Charlotte Storm Water
600 East Fourth Street
Charlotte, N C 28202-2844

Rezoning Petition Review

Rezoning Petition #: 20-120

Location of Property: Approximately 21.62 acres located on the south side of Ridge Rd and north of I-485.

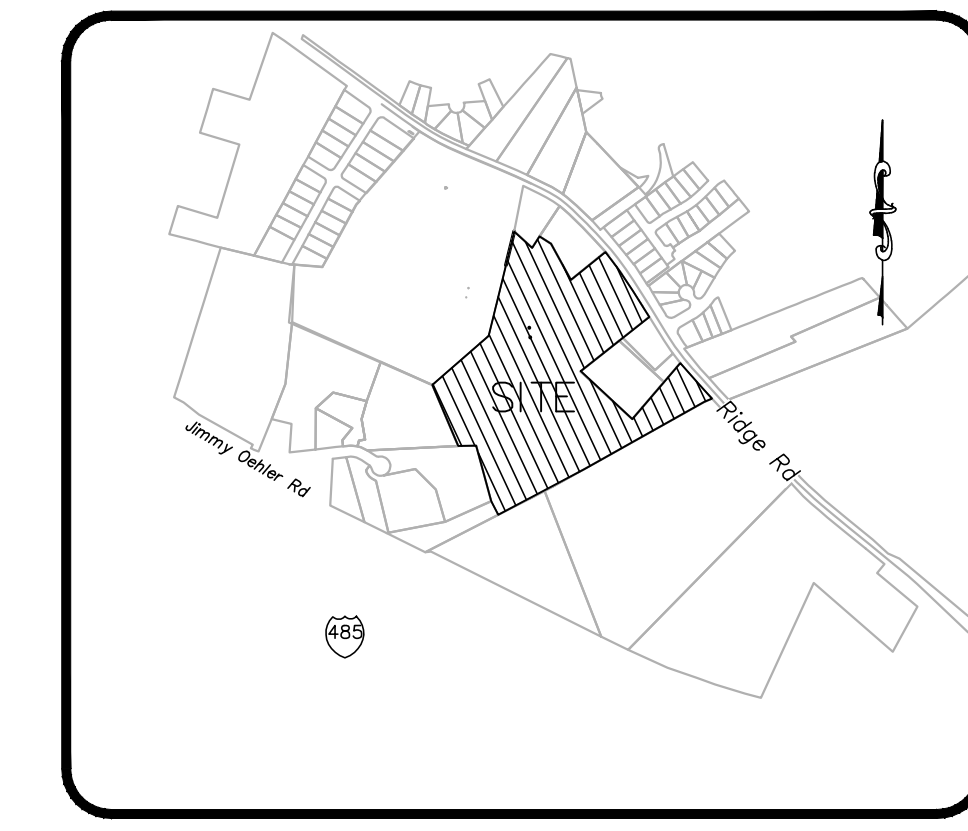
Recommendations Concerning Storm Water: Please clearly map and show FEMA limits on the rezoning plan sheet.
